MYNYDD Y GWYNT WIND FARM

Ref: EN010020

WRITTEN SUMMARY OF ORAL CASE ON BEHALF OF POWYS COUNTY COUNCIL – ISSUE SPECIFIC HEARING ON CULTURAL HERITAGE – WEDNESDAY 18TH MARCH 2015

26th March 2015

Figure 14.1

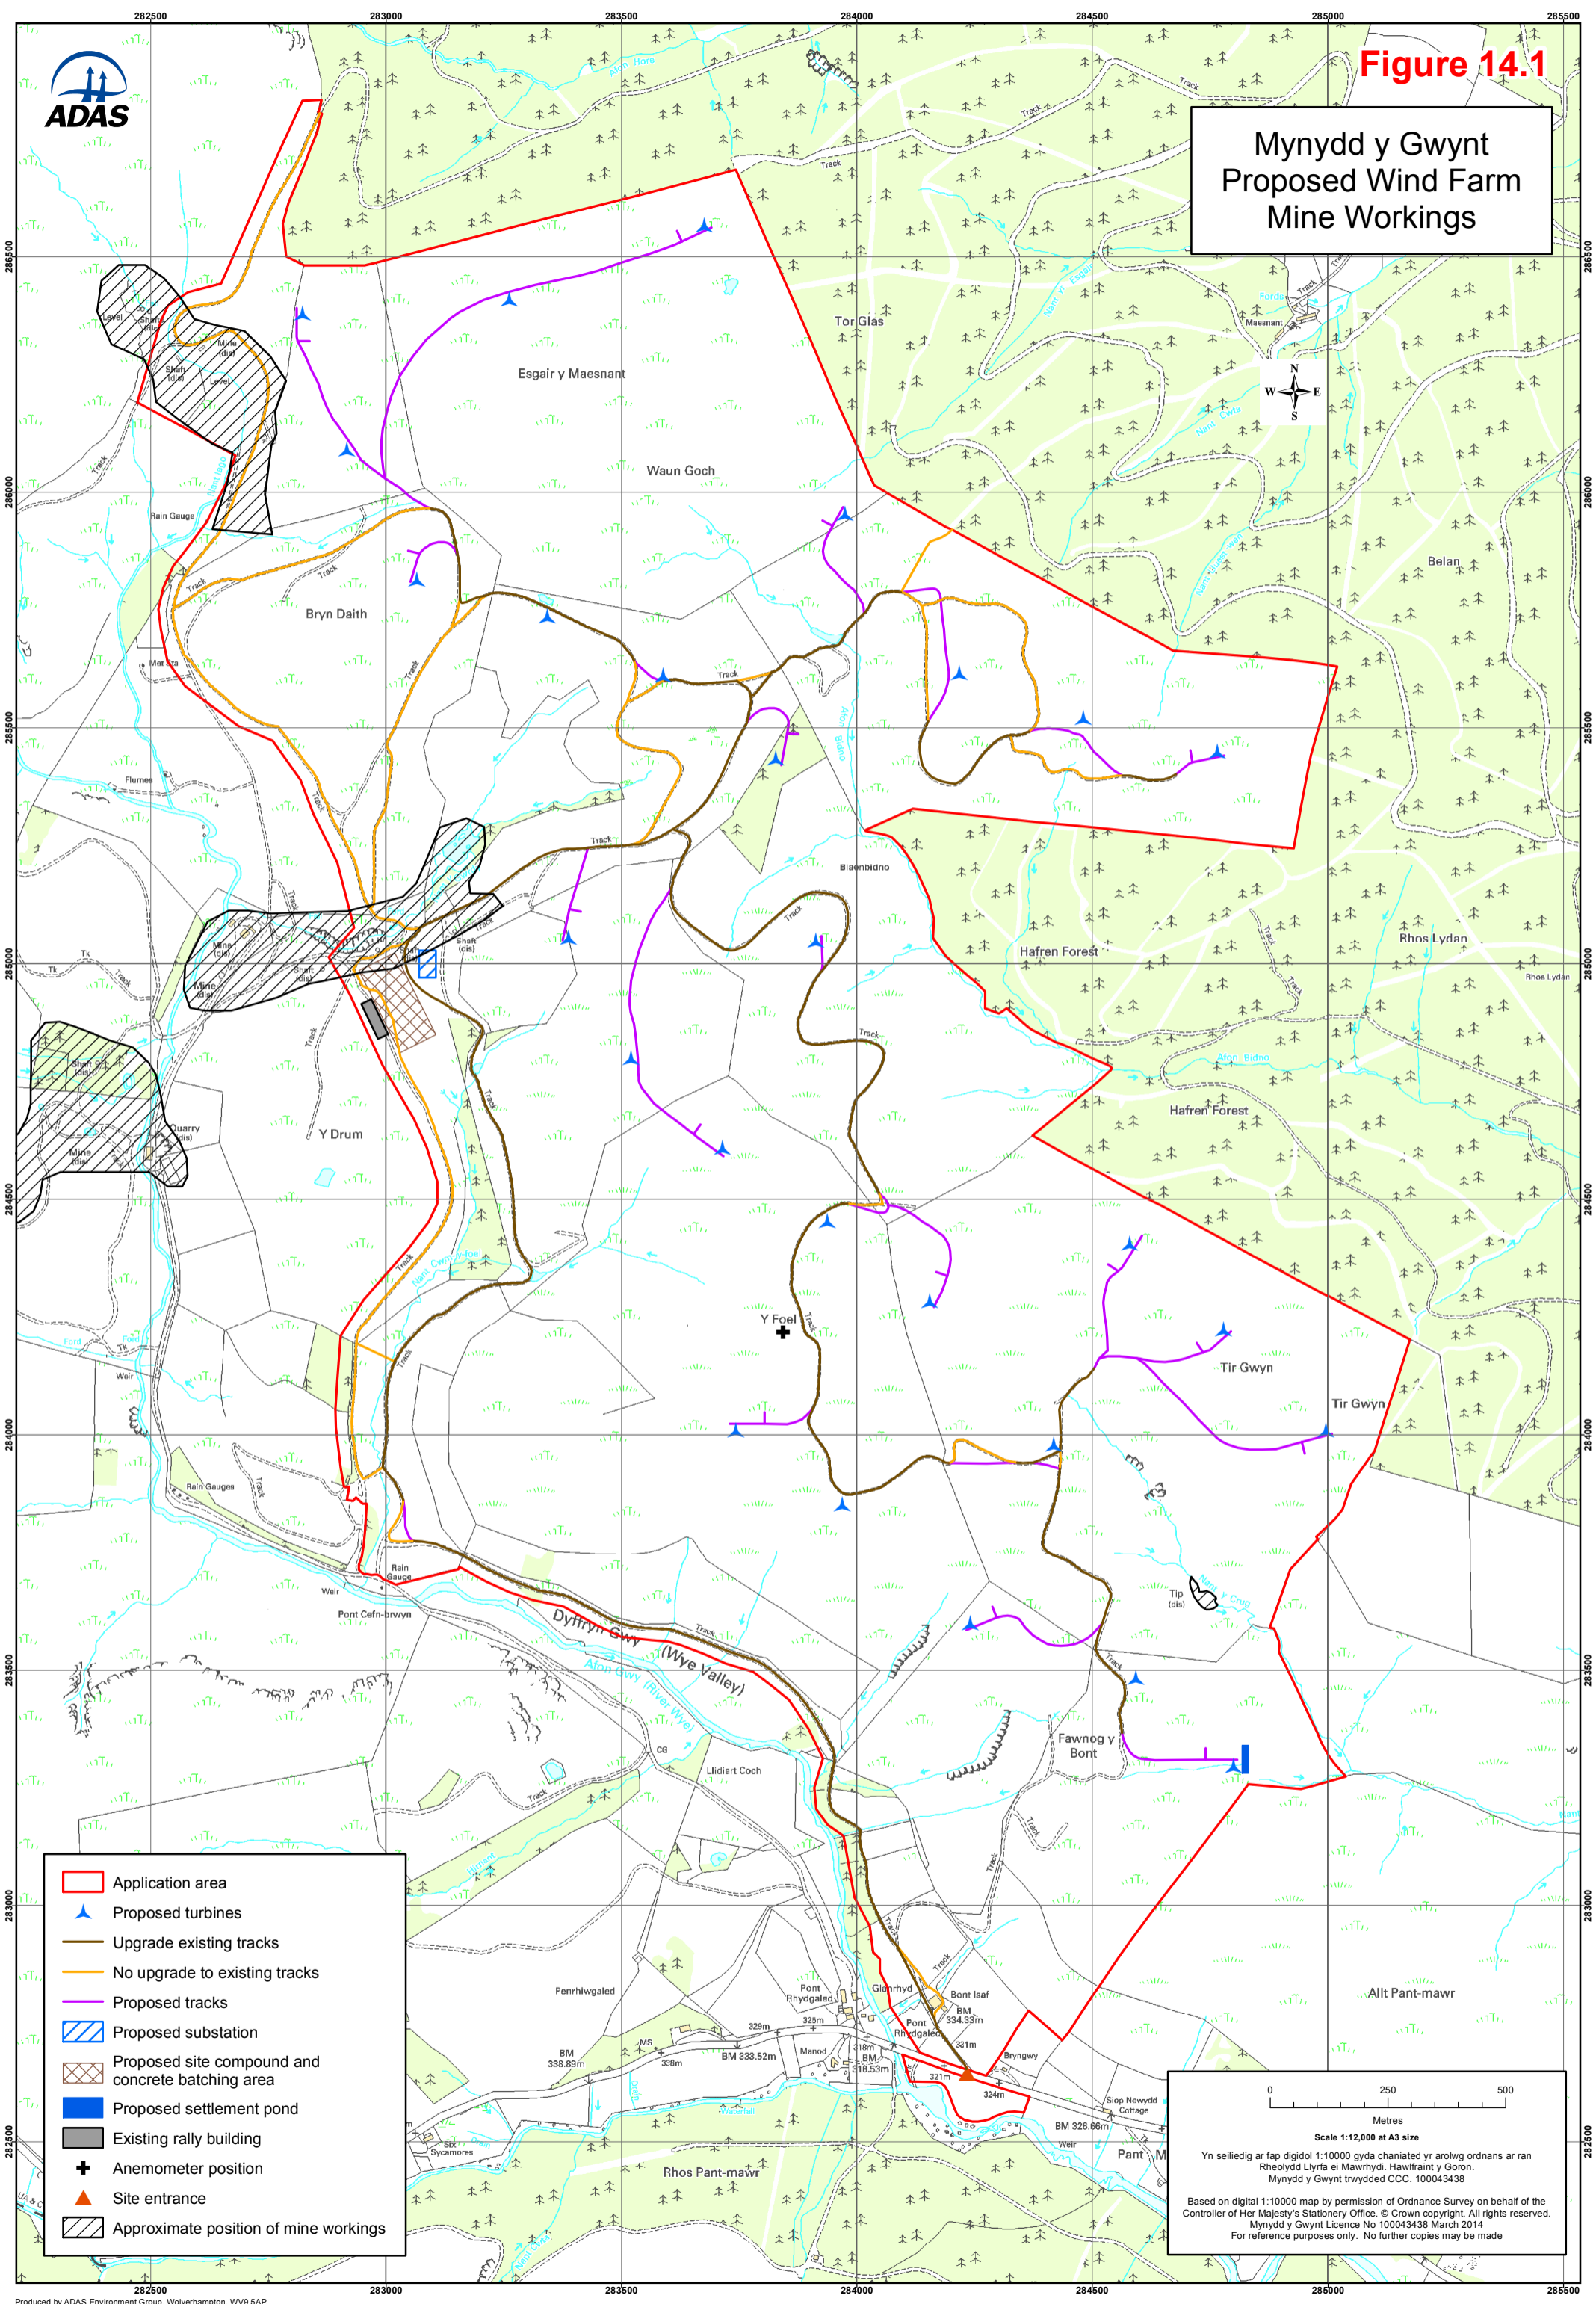
- 1.14. As with the Cairns (see above) the applicant has once again taken a narrow and limited view of what comprises the significance of the scheduled Nant yr Eira mine complex and nationally important but non-scheduled Nantiago Mine complex and how their setting contributes to their significance. They have focussed entirely on the evidential and historic values relating to the technological and process elements of the mines, this is very much a limited archaeological perspective. They have not taken into account the broader social history of the mines, their wider historical context in relation to the rapid growth and collapse of metal mining in 19th and 20th century Britain, the way in which the mines were planned, developed, operated and why they failed etc. Consequently, they have a very limited view of what aspects of setting contribute to the significance of the mines and give absolutely no weight to the current open and uncluttered form of the landscape and the remoteness of that landscape as factors that contribute towards their significance.

- 1.15. PCC's view, as articulated in more detail in our LiR, written representations and other responses, is that the remoteness of the mines and the open upland character of the landscape they are situated in are key elements of their story and significance in terms of how they were planned, developed, operated and ultimately why they failed. Their remoteness and their upland location are central to their story and to understanding how they fit in the wider UK picture of post-medieval metal mining. There are other similar upland metal mines in Mid Wales, the North Pennines, Cumbria and the Yorkshire Dales all which occupy remote rural locations and all of which developed, expanded and ultimately failed in similar ways to of the scheduled Nant yr Eira mine complex and the Nantiago Mine complex. The remoteness and upland setting of the mines is therefore a key element of their story and significance. The fact that these mining complexes survive in a remote and uncluttered upland landscape also enhances our ability appreciate and understand their significance and story (see definition of aesthetic value above).

- 1.16. PCC has identified that the scheme would result in Less than Substantial Harm to the scheduled Nant yr Eira mine complex due to very substantial changes to its setting (the applicant accepts that there would be extensive change to setting – see paragraph 2.5.6 of Appendix 6.2 of the 19th January submission) which directly affects its sense of remoteness and openness. A similar finding of less than substantial harm has been identified for the

nationally important but non-scheduled Nantiago Mine complex, in this case we have assessed the harm as being a long way up the scale of less than substantial.

- 1.17. The applicant has identified no harm to either mine complex due to their limited definition of significance and the contribution that setting makes to it; we are of the view that this is an incorrect assessment that substantially underplays the actual scale of harm.
